From: Harry Chalk
Sent: 06 May 2025 08:09
To: Planning.Responses
Subject: FW: AB/43/25/PD - Riverside House
Attachments: Existing Floorplans and Elevations (2).pdf; Proposed Floorplans (2).pdf; Proposed North-East Elevation (2).pdf; Proposed North-West Elevation (2).pdf; Proposed South-East Elevation (2).pdf; Proposed South-West Elevation (2).pdf; Sub Plan Action Sheet.docx

Subject: AB/43/25/PD - Riverside House

Following the previous planning appeal decision (APP/C3810/D/24/3339003) and notwithstanding The Local Planning Authority's sole reason for objection under AB/117/23/PD, the Planning Inspector found that there were additional components of the proposal that did not comply with the relevant criteria of Schedule 2, Part 1, Class AA. Notably, he Inspector identified that the single storey front bay, rear two-storey bay, and the single-storey front lean-to do not form part of the principal part of the dwellinghouse. As such, they concluded that these components prejudiced the schemes compliance with Class AA. I do note that the additional storeys above the garage have now been removed to address our prior concerns, but I also note that the additional two storeys continue to a

PROPOSED NORTH-WEST ELEVATION

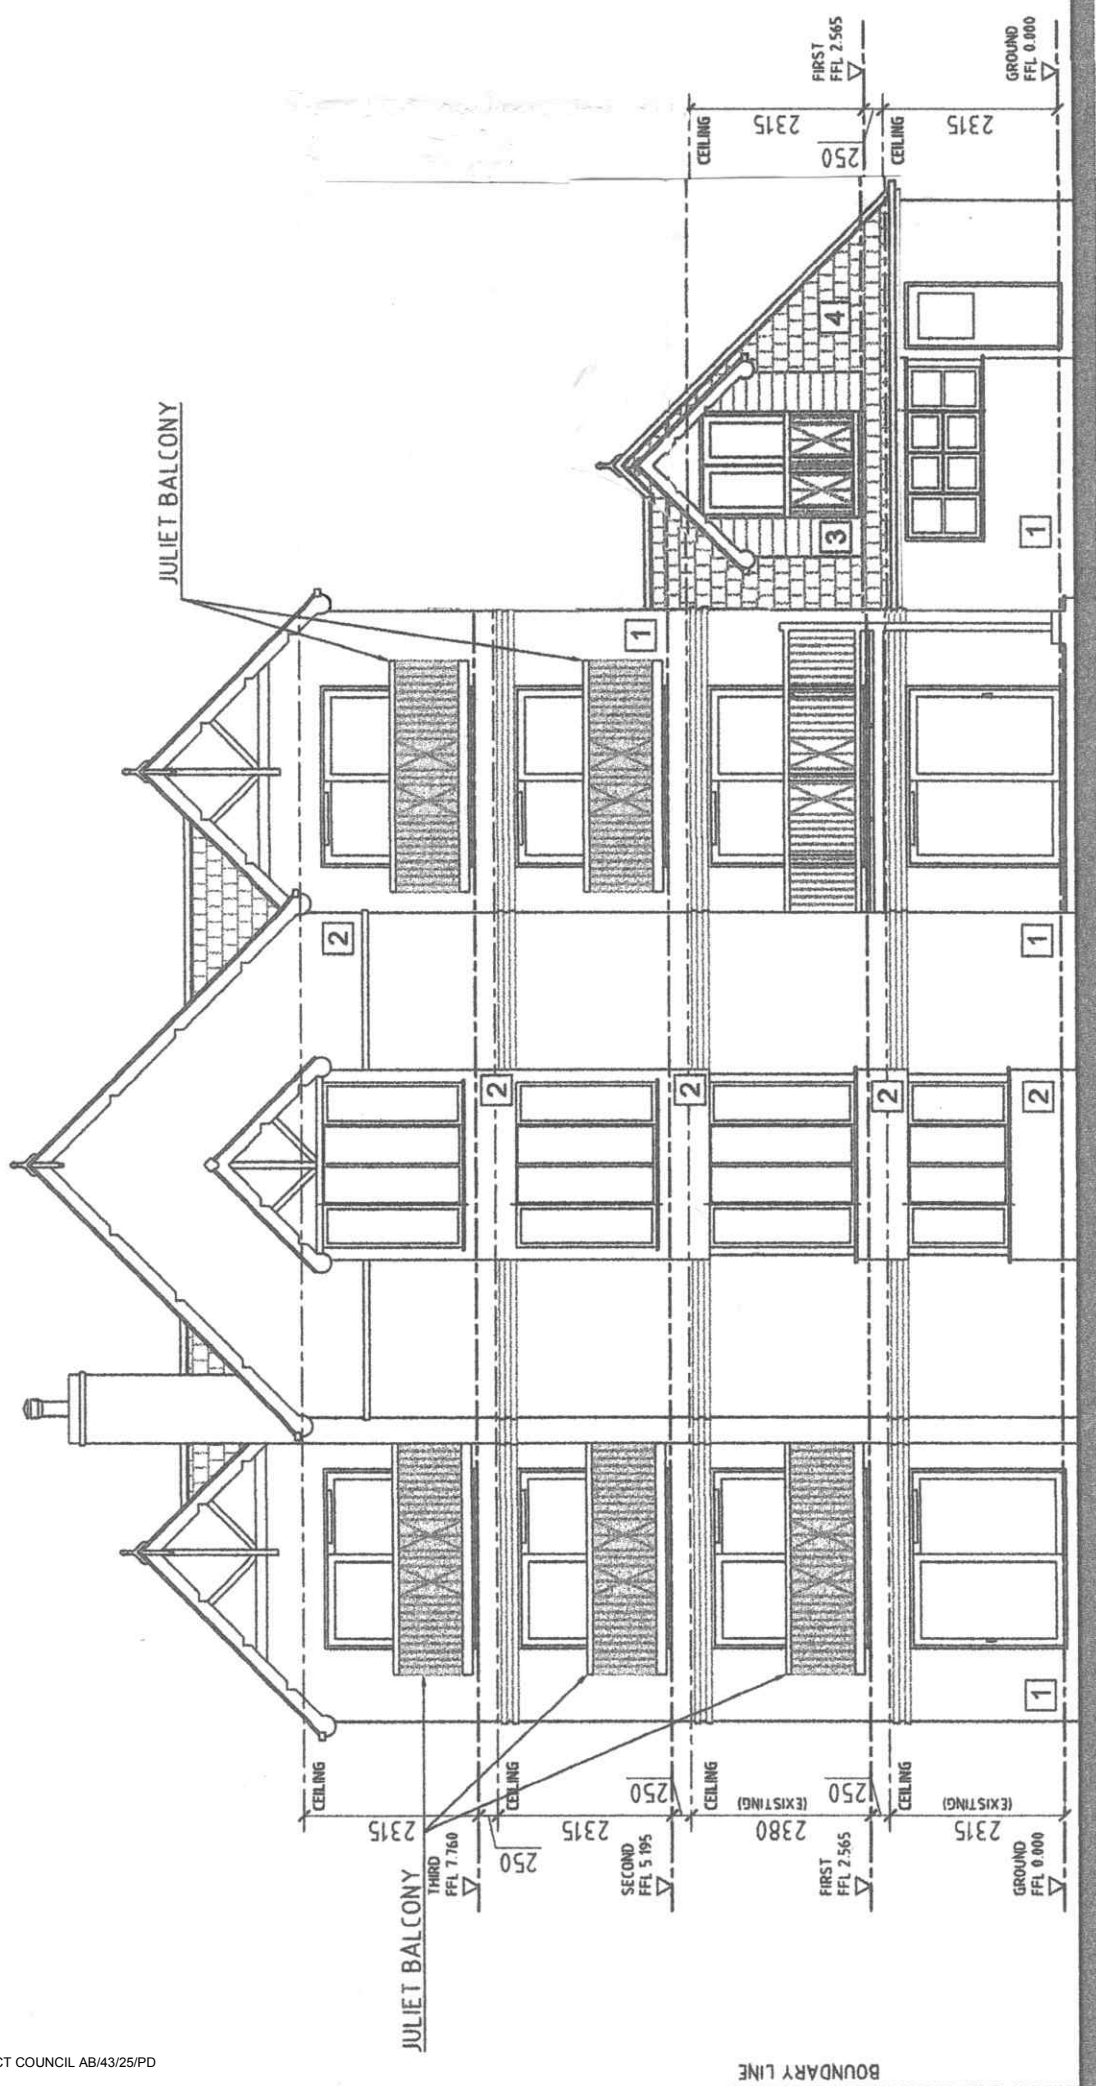
I would ask that the existing and proposed elevations be amended to remove the additional storeys from the bay and lean-to features identified by The Inspector, and to ensure the minor inaccuracies identified are addressed accordingly. Provided these amendments can be made by 09/05/25, we will have them uploaded and consider them further within our assessment of the application. In lieu of these amendments, it is clear that the proposal should be 'refused' in its current format in line with the prior conclusions of The Inspector.

Please find attached the amended plans, which, I hope, will satisfy all the points of your below email.

EXISTING PLANS AND ELEVATIONS

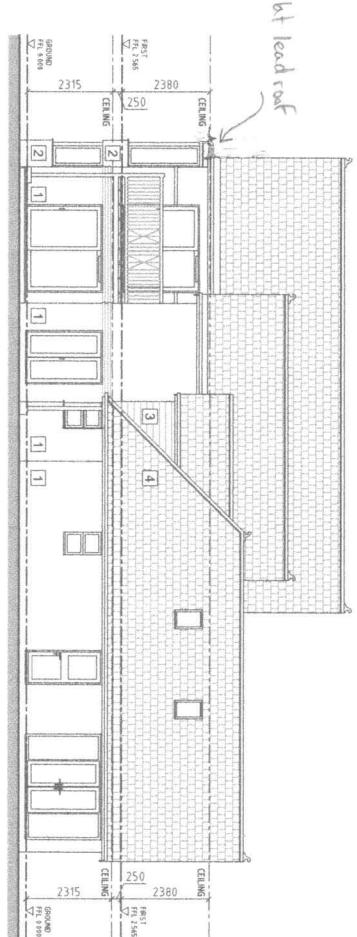
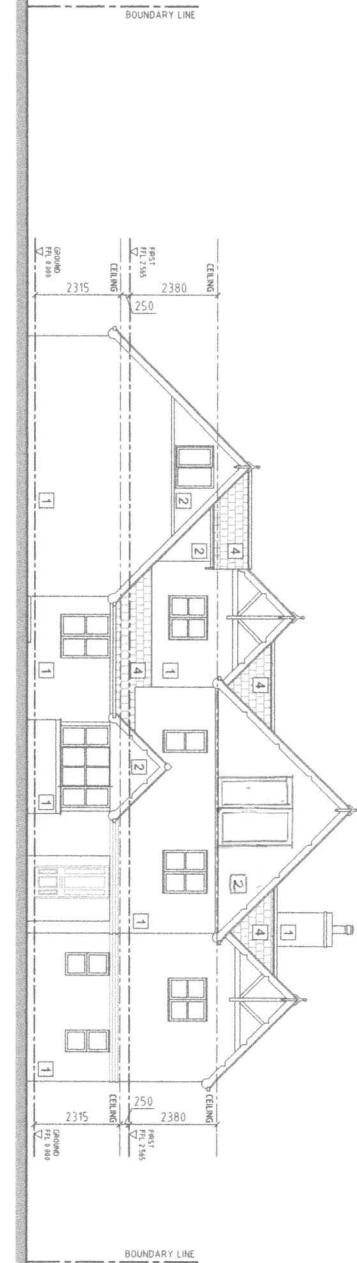
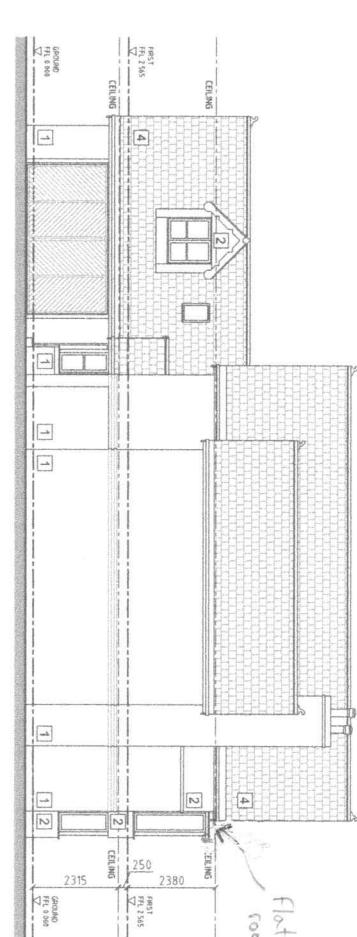
I also note that The Inspector found some inaccuracies in the existing elevations, these being the lack of a pitched roof to the rear tow-storey bay feature and the absence of the French doors to the front and rear central gables of the roof.
